July 5, 2018

PROJECT: 44395.1.1 (U-5824) Forsyth County
Widen NC 66 (Old Hollow Rd) in Walkertown from Harley Dr. to US 158

SUBJECT: Final Design Field Inspection

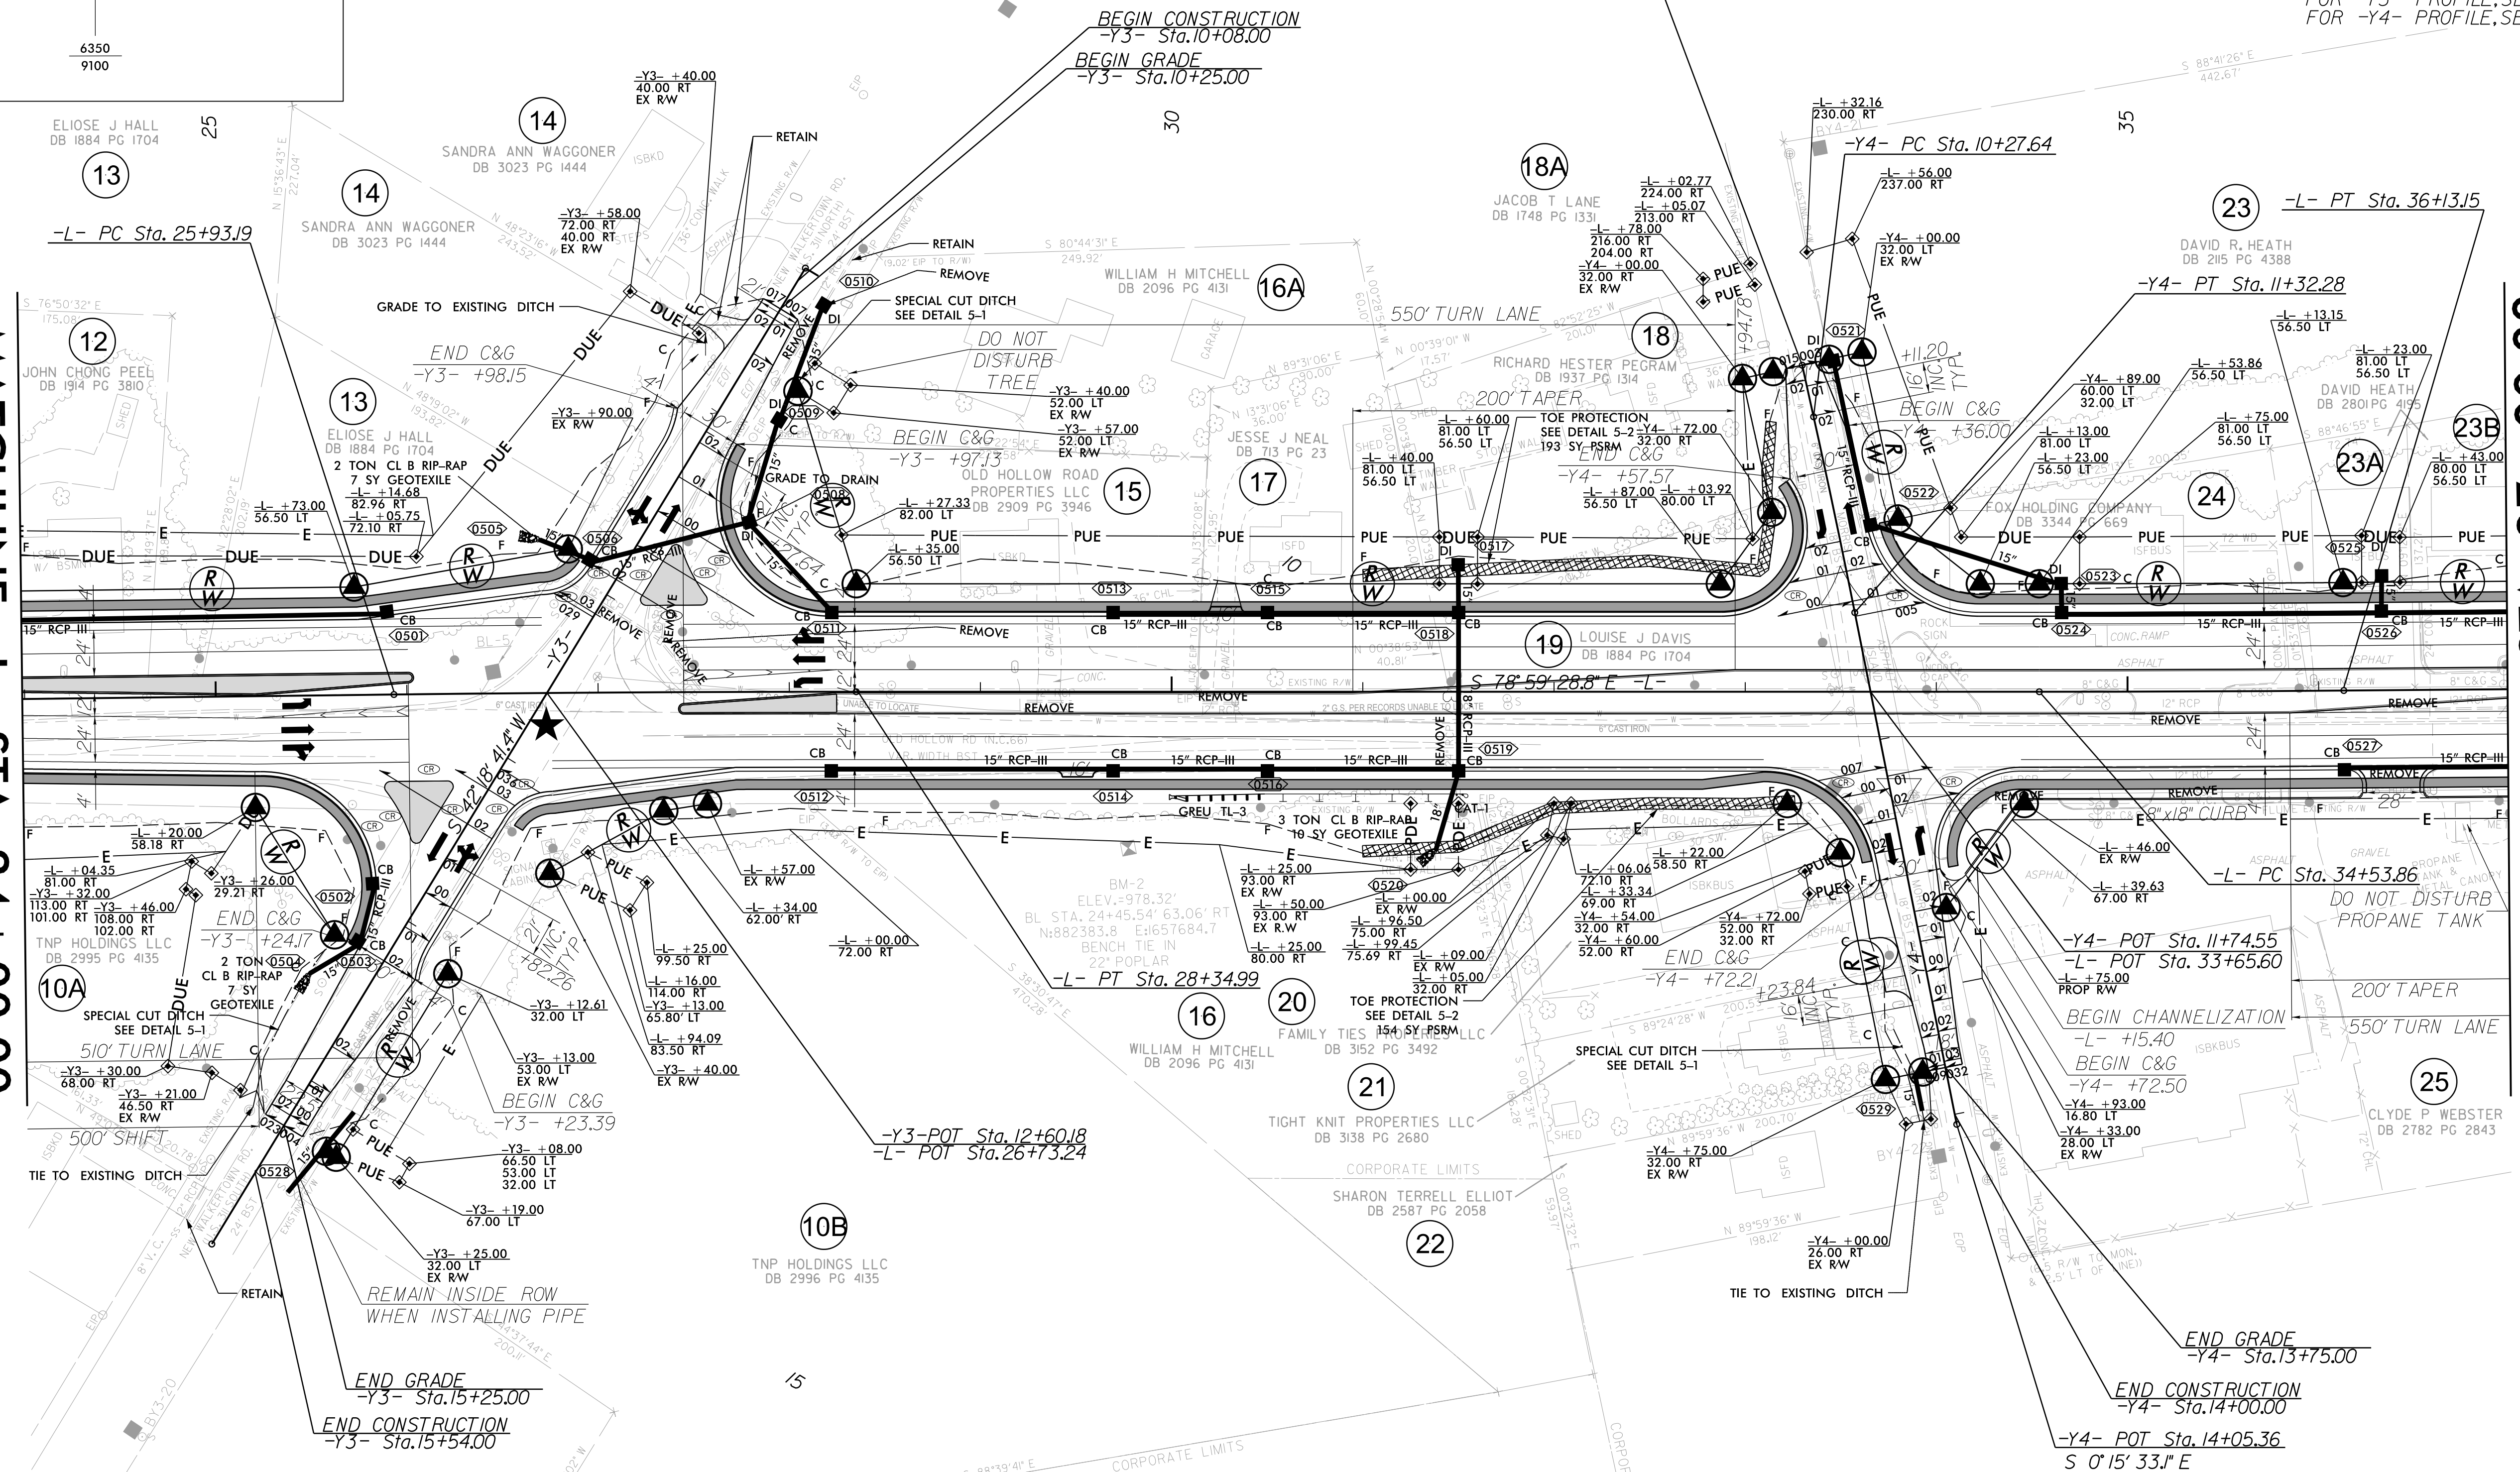
- Parcel 26 extend C/A to Parcel 27 property line
- Correct profile , see sheet 13 to 17

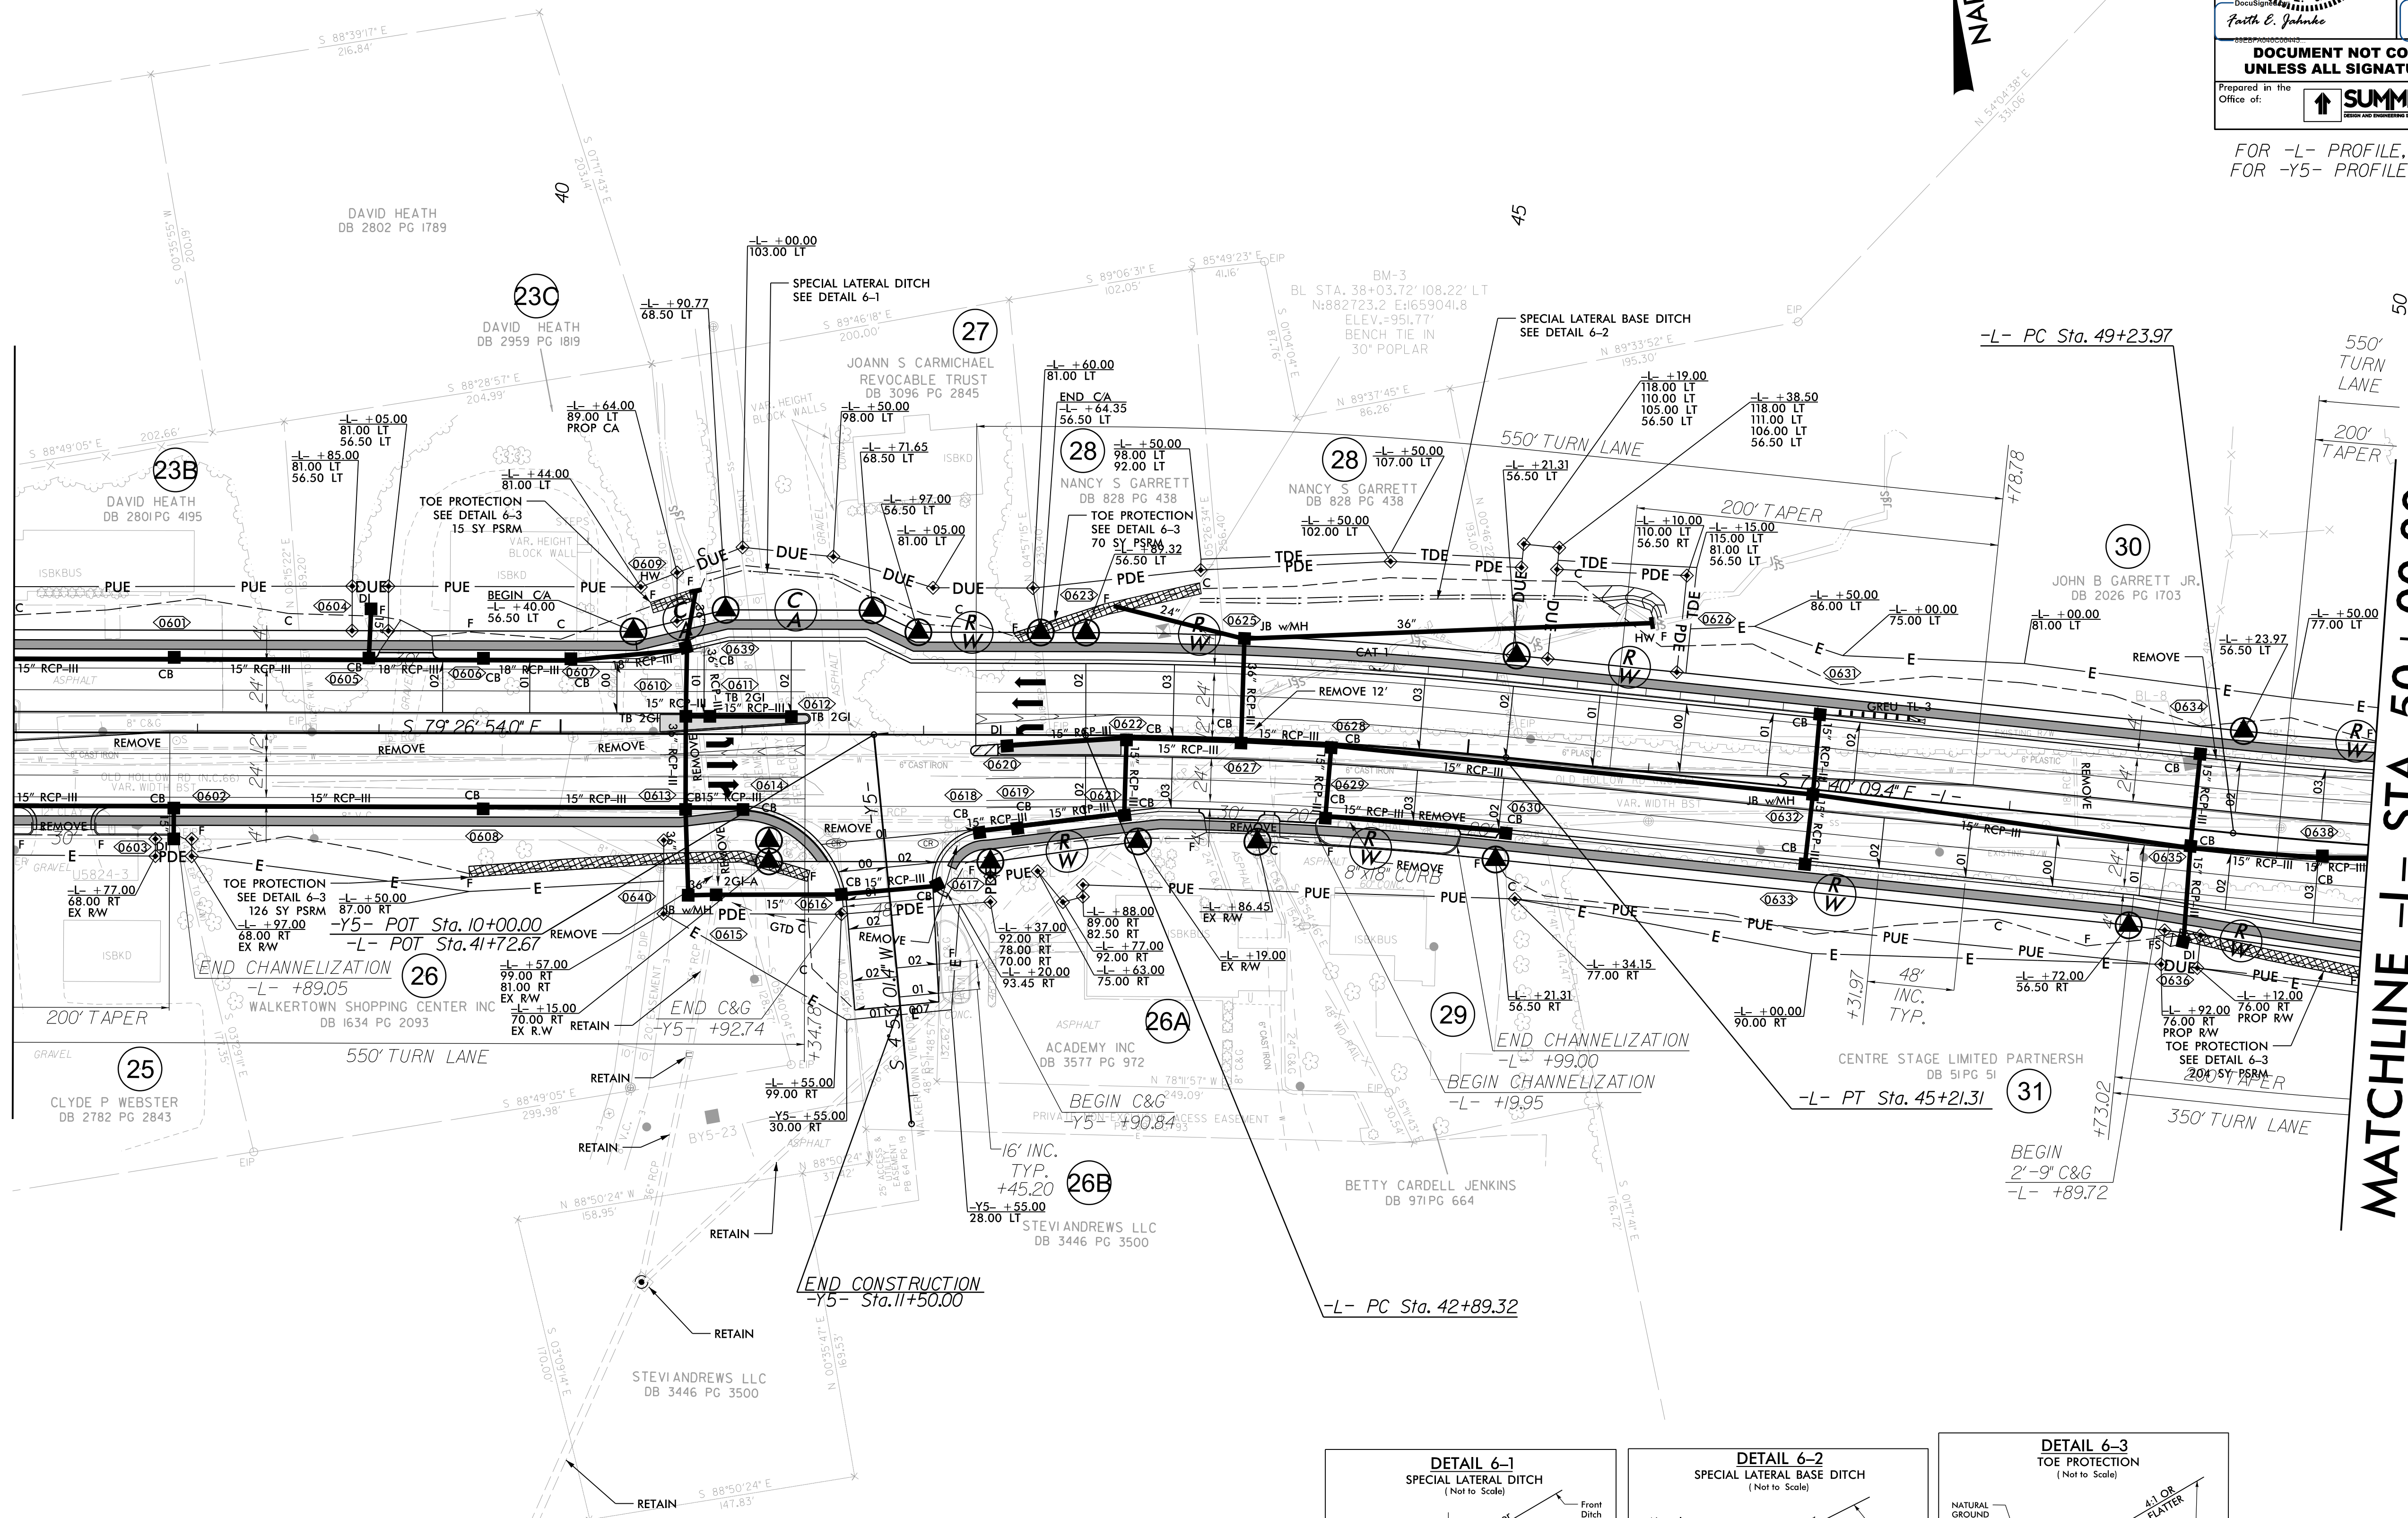
- Parcel 31 pull in TCE
- Parcel 33 Pull in TCE
- 0713 relocate box
- Parcel 32 remove TCE in PUE
- Add signal symbol @ Y-7
- Review adding retaining wall on Parcel 32 and 34
- 0727 convert to DI
- Correct turn lane length

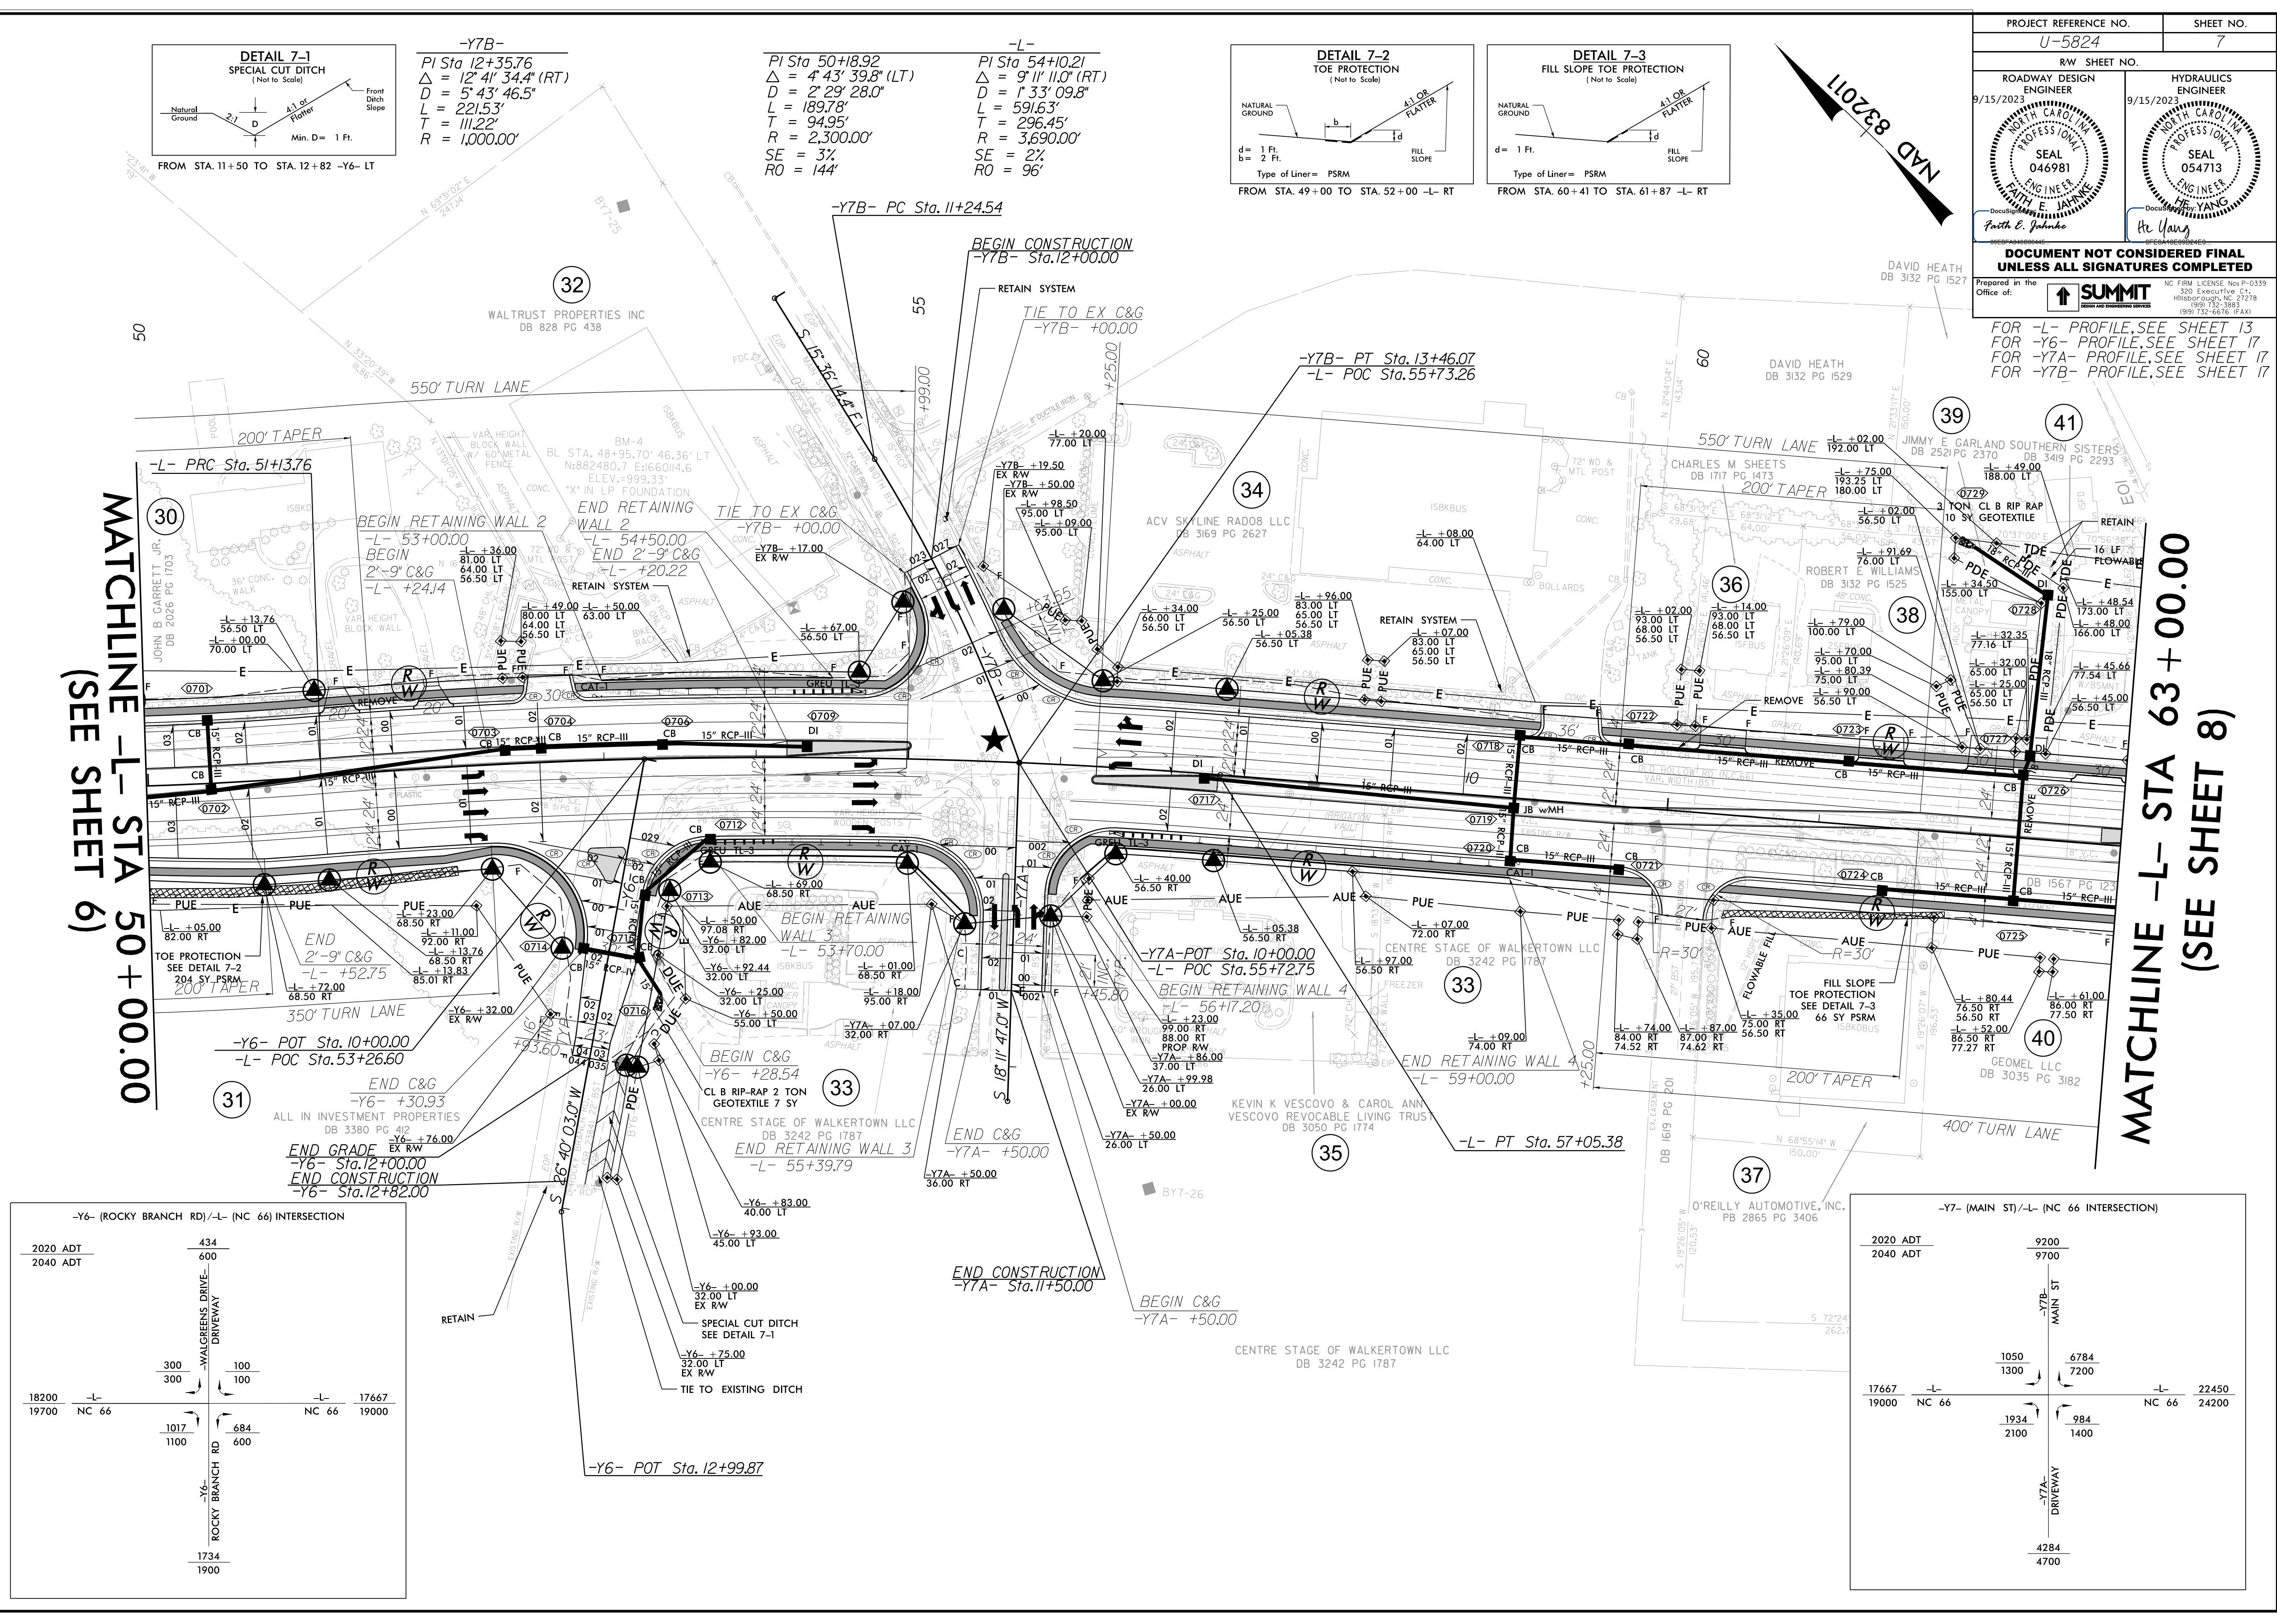
- Review drainage across parcel 39 either add drainage structure in curb line or shift 0801 toward Y-8A
- Parcel 49 tie easements to existing ROW
- Add signal symbol
